WELWYN HATFIELD COUNCIL – DEVELOPMENT CONTROL
DELEGATED REPORT

APPLICATION No:	S6/2007/1521/FP
------------------------	-----------------

The proposed development would involve the removal existing gates and piers to the two vehicular entrances of the site. Replacement gates and pillars would be erected.

ELEVATION - Proposed North Gates 1:200

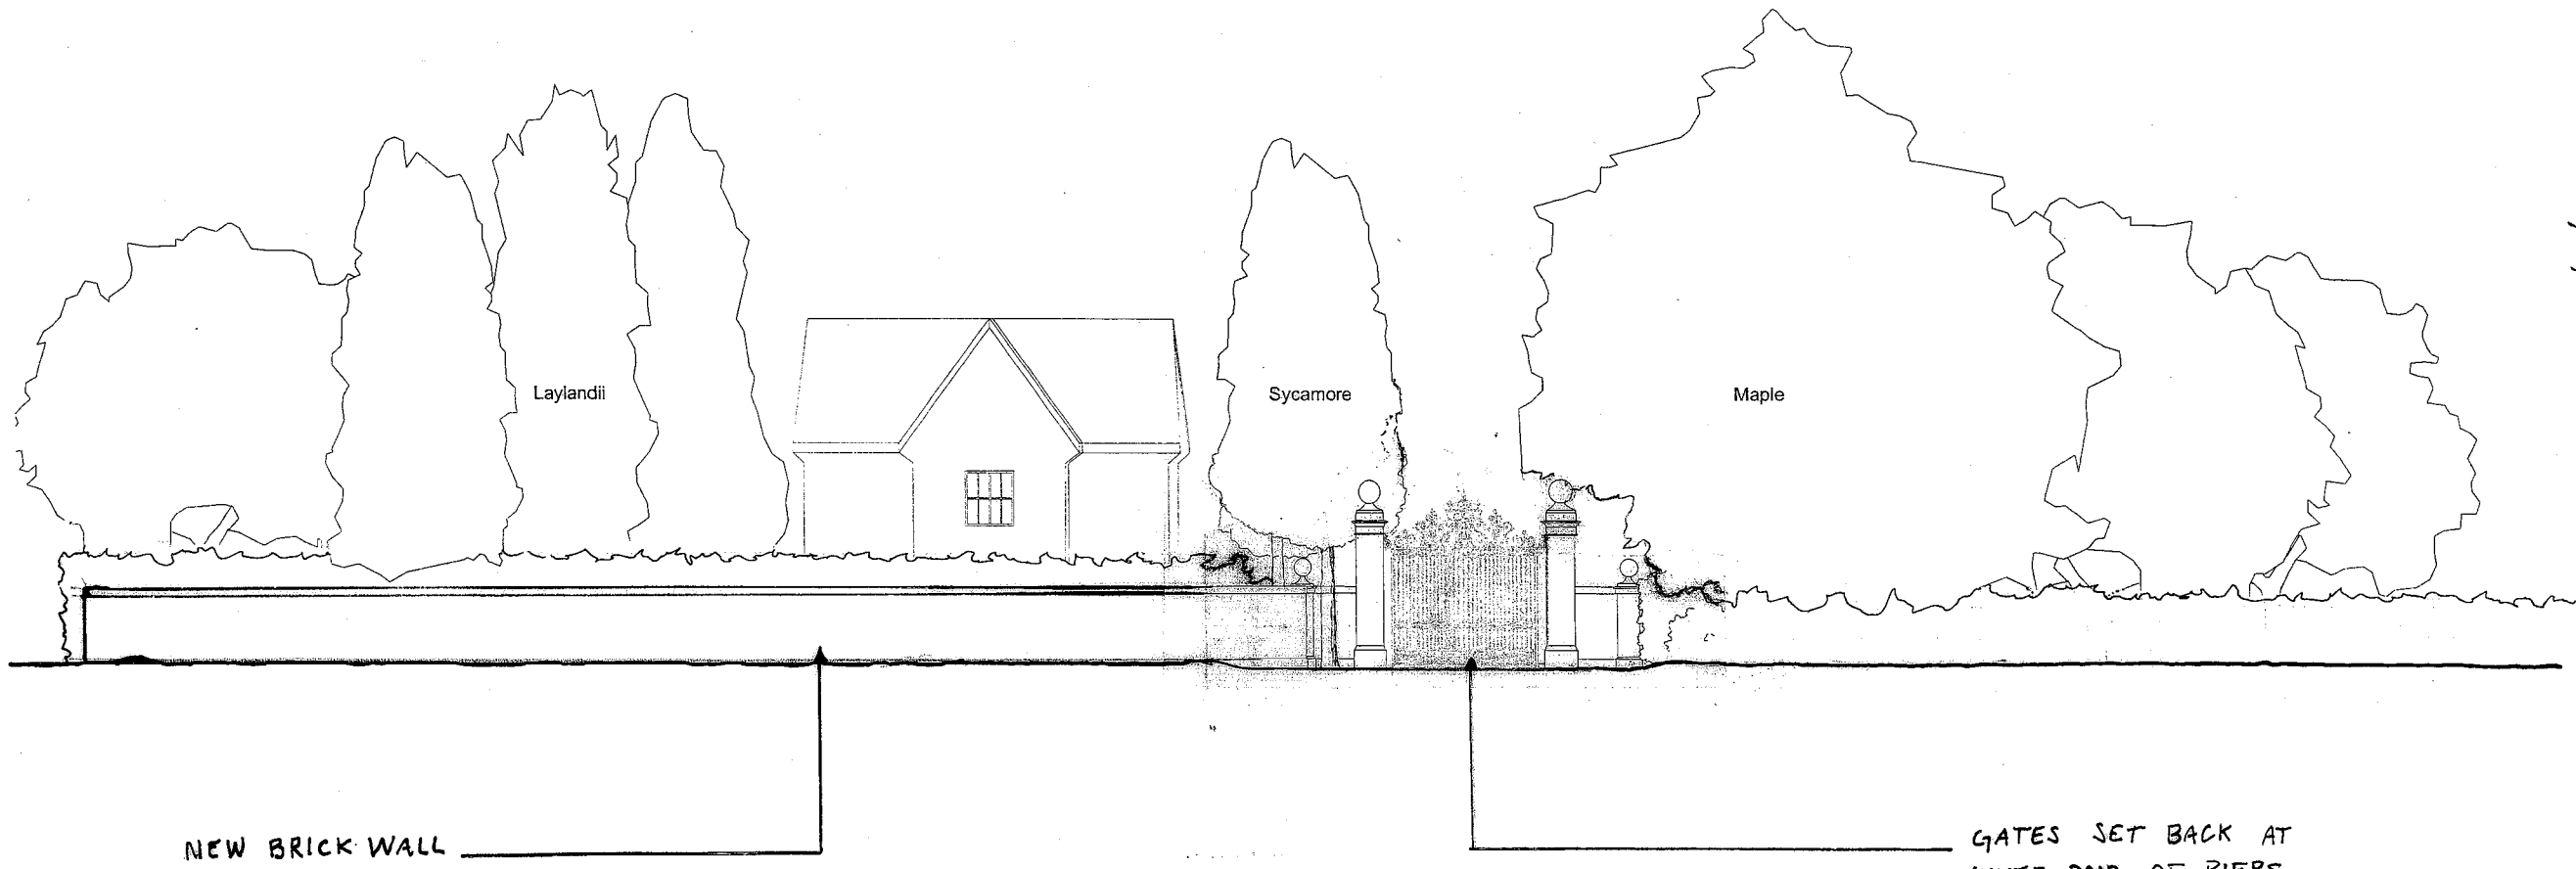
To the north of the site the plans illustrate gates in two positions. It has been confirmed by the agent, that this application is only applying for the gates set into the grounds and the gates and wall close to the public highway were to illustrate the details of a possible future application. The proposed gates to the north are of a more elaborate design as they from the main entrance to the dwelling. Although, these gates would be elaborate they would be set back from the public highway by approximately 26m. When viewed from the surrounding areas these gates would be against the backdrop the main house and grounds. Due to the large area of land surrounding the proposal and trees and vegetation within view, the proposed gates would not appear particularly prominent.

4. Notwithstanding the details on the approved plans, the proposed north gates are only granted planning consent in the position furthest from St Albans Road, which is labelled as being short-term. A further application would be required to reposition the gates and construct a new brick wall close adjacent to St Albans Road.

PROPOSED SOUTH GATES VIEW FROM WILKINS GREEN LANE
 1:50

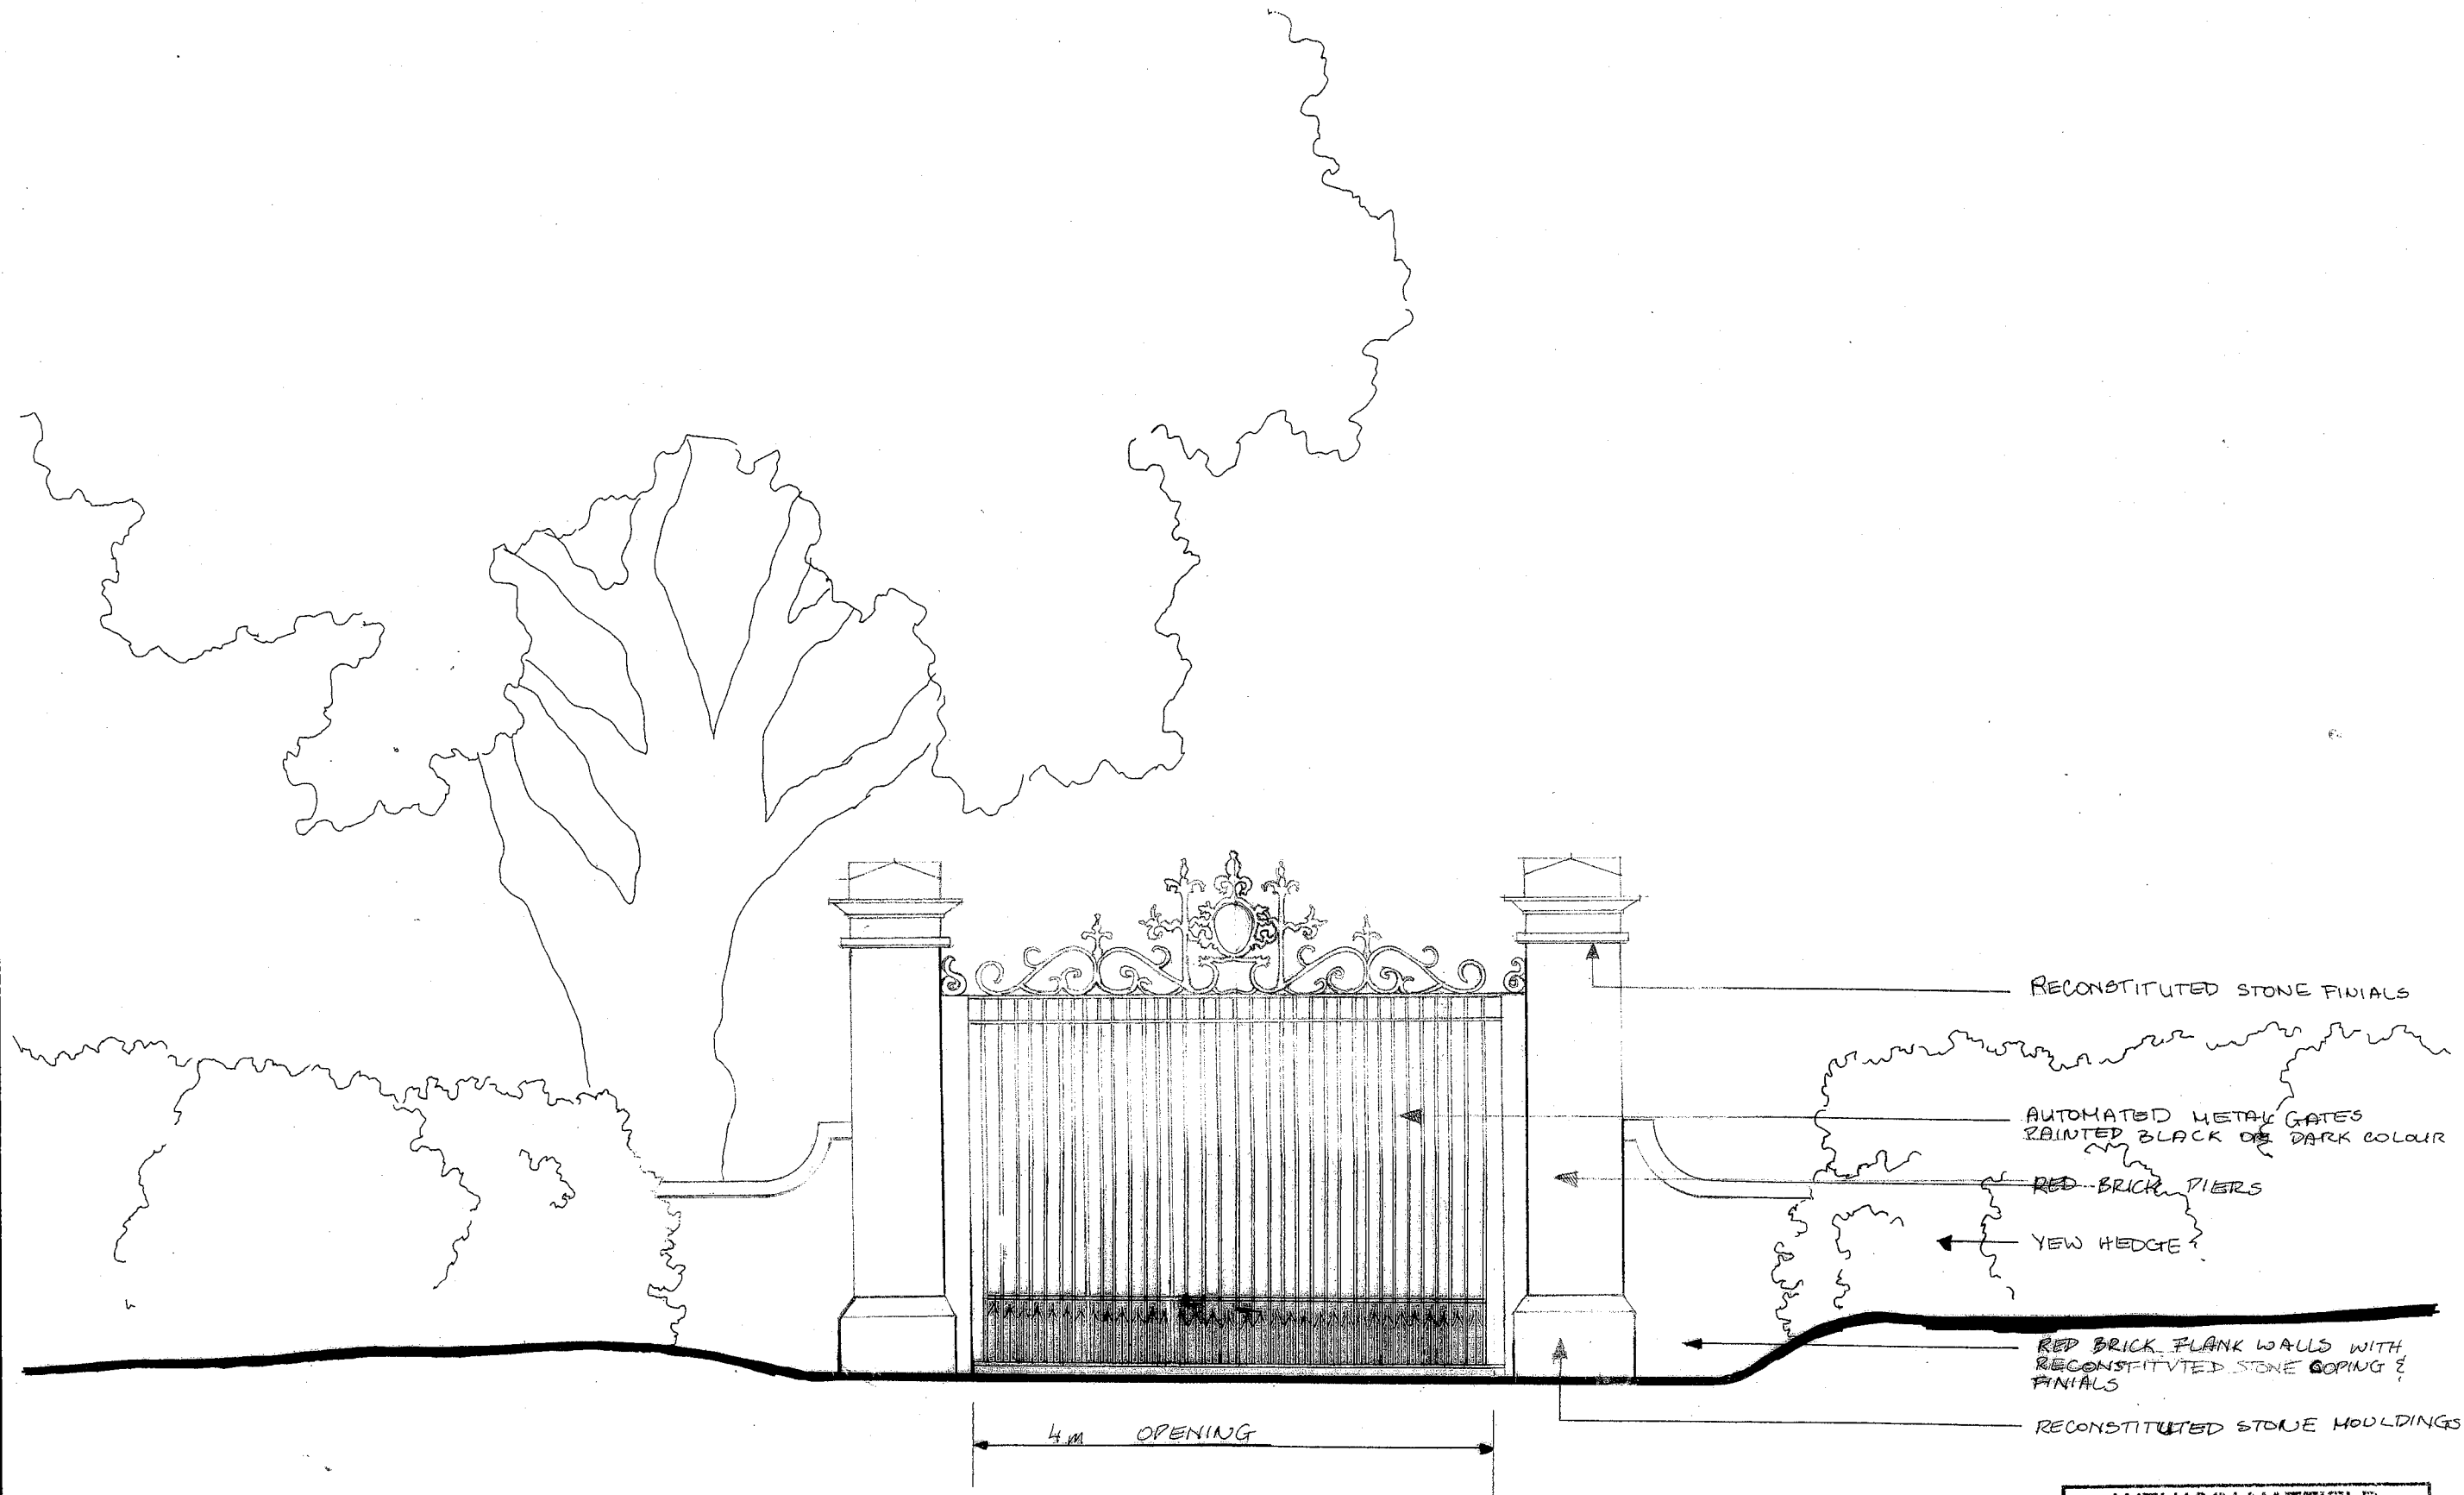
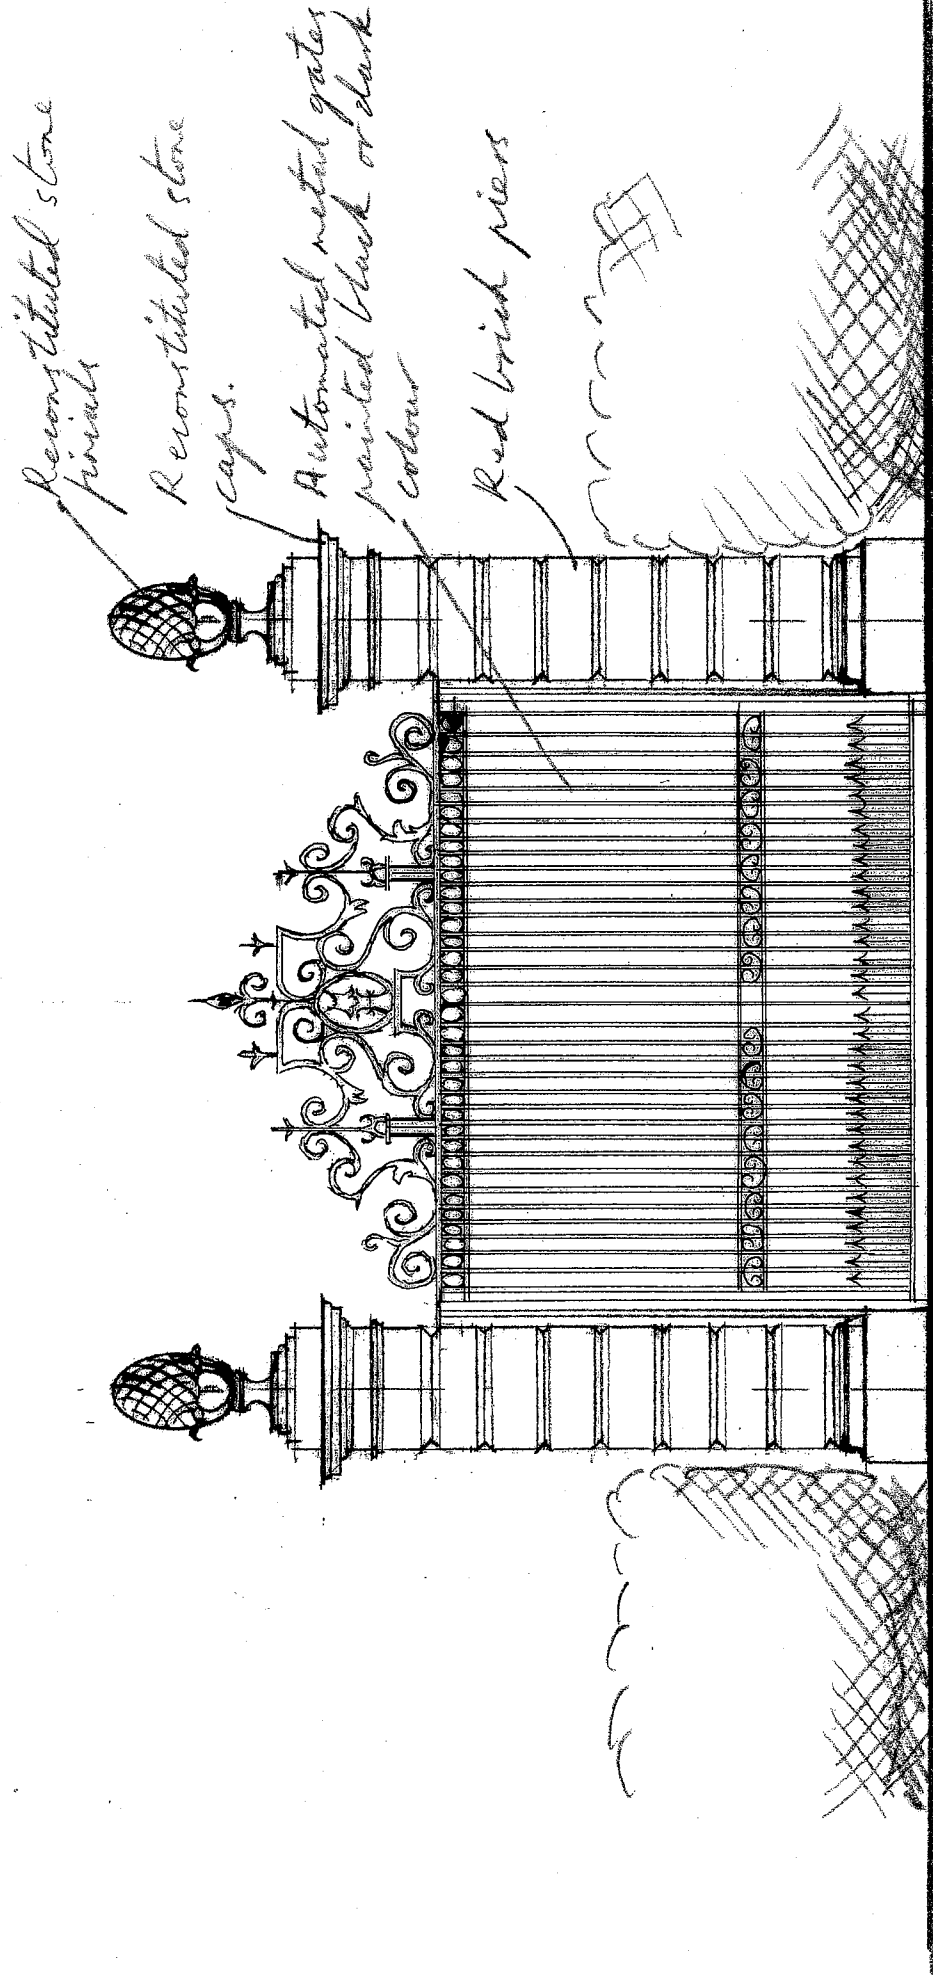
To the south of the site it is proposed to erect a set of gates at the entrance to Wilkins Green Lane. These gates and would be similar to the proposed north gates but have a simpler design. The proposed gates would measure 4m in width by 4m in height. The proposed pillars would measure 4m in height and have small sections of lower wall either side, both would have reconstituted stone features. The existing trellis along this boundary would be removed.

To the south of the site the proposed gates would be relatively close to the boundary. Several examples of tall vehicular gates are within the surrounding street scene albeit more modest in appearance. Due to the substantial elevation of the main dwelling, which is clearly viewed from the street scene, the proposed gates would not appear out of place as an access to this dwelling. The proposed development would involve the removal of the existing pillars and the existing trellis, which is near some of the southern the boundary. The proposed development would not have an adverse impact upon the character and appearance of the locality. The proposed development would comply with Policies R25, D1 and D2 of the Welwyn Hatfield District Plan 2005.

1. C.2.2 – Time Limit Full Permission – Listed Buildings
2. C.5.1 – Materials to be submitted and agreed
3. The proposed entrance gates shall be set back a minimum of 6.0m from the edge of carriageway/back of the footway and shall open inwards into the site.

Great West Hyde House 6103/19
 1:50. RT 7/9/07.

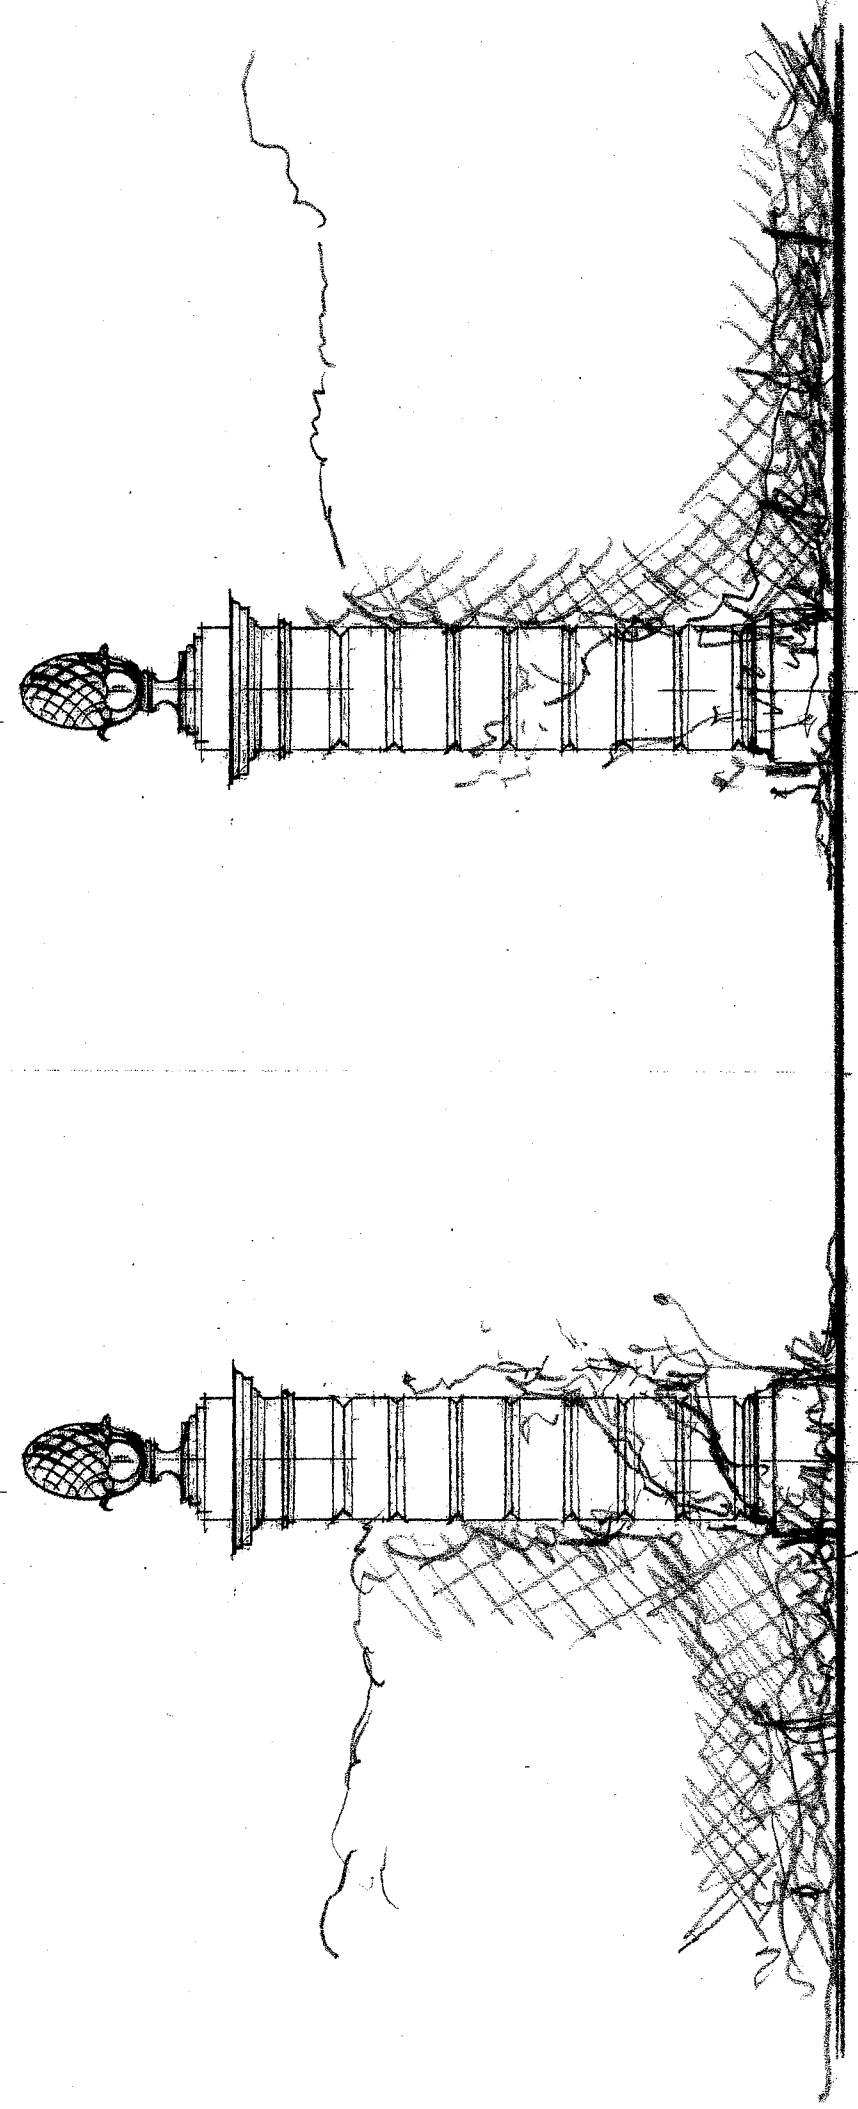
To the north of the site it is proposed to erect a set of gates within the site in a position that would enclose a tree lined avenue which leads to the residential area of the site. These gates would be set back from the boundary with the highway by approximately 26m and would measure 4m in width by 4.9m in height. These gates would be hung off of brick pillars measuring 1m in width that would have a maximum height of 5.4m. The proposed pillars and gates would have an ornate design with reconstituted stone features. It has been proposed to densely plant yew hedges to the outsides of the pillars to create an enclosure. The agent has confirmed that the application does not include the gates and wall that have been illustrated adjacent to St Albans Road.
